## **Application by Four Ashes Limited for an Order Granting Development Consent for the West Midlands Interchange**

### **The Examining Authority's written questions and requests for information (ExQ1)**

**Issued on 4 March 2019**

Figure 12.6 **A**

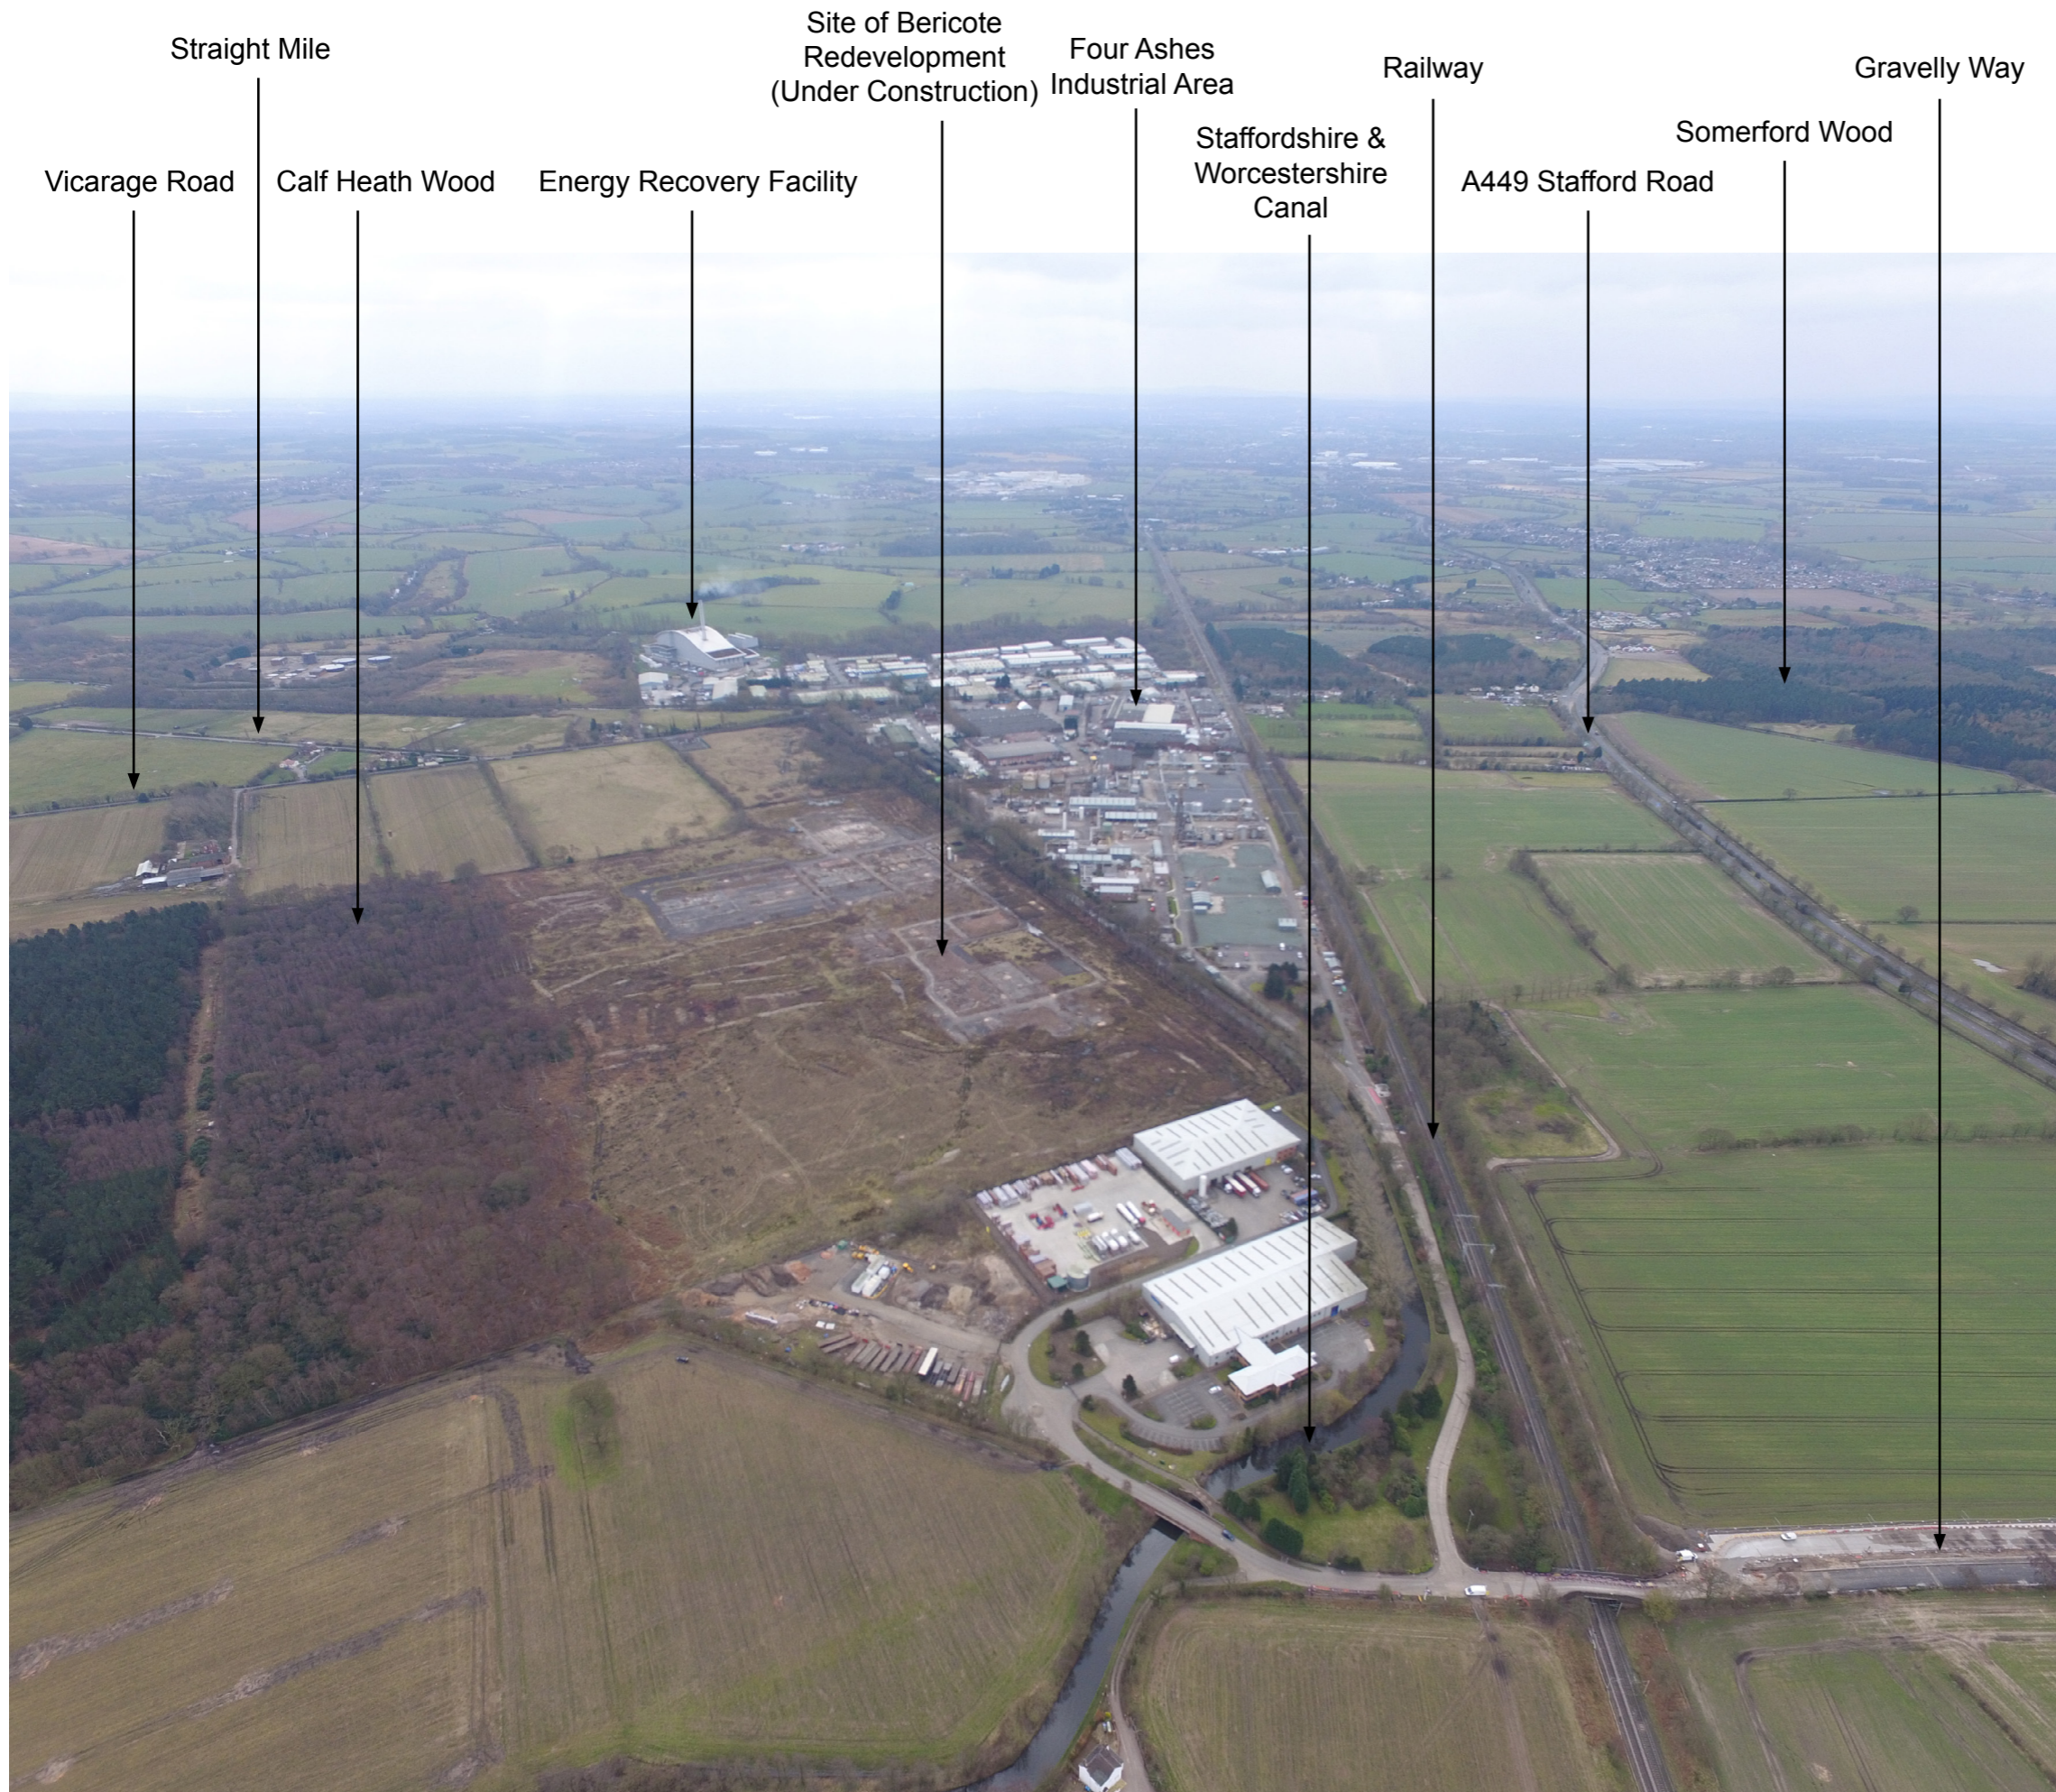
ExQ1	Question to:	Question:
1.0	<b>General and Cross-topic Questions</b>	
1.0.1	The Applicant and SSDC	<p><b>Existing Land Uses.</b>          Some of the base plans used in the submission include the notation 'Caravan Park' on land to the west of Croft Lane. This use is not evident on the aerial photographs in ES Figure 12.6 and does not appear to have been referenced or considered in the ES.</p> <p>(i) Does the use still exist and, if so, does it include any permanent residential use?</p> <p>Yes the current position is that planning permission was granted in 7.2.1961 (for 6 caravans) and 26.2.1963 for 3 additional caravans (copy enclosed of the site licence and planning permissions).</p> <p>In addition there is a planning permission in place under 18/00141/FUL for a mobile home. Copies of the 2018 permission and supporting reports can be supplied or can be viewed here - <a href="https://services.sstaffs.gov.uk/sscwebviewer">https://services.sstaffs.gov.uk/sscwebviewer</a></p> <p>Under the permission 18/00141/FUL, for retention of existing mobile home, the following condition was imposed:</p> <p><i>1. The mobile home hereby approved shall be removed from site within two months of it no longer being required to provide accommodation for the applicant's father, and shall thereafter be returned to grassland.</i></p> <p>In addition there is an extant site licence for 9 caravans to be stationed (in accordance with section 3 of the Caravan Sites &amp; Control of Development Act</p>

<p>1960).</p> <p>(ii) If not, is there a planning permission in place or other means by which such a use could be resumed or resurrected in this location and could this include any permanent residential use?</p> <p>See above</p>
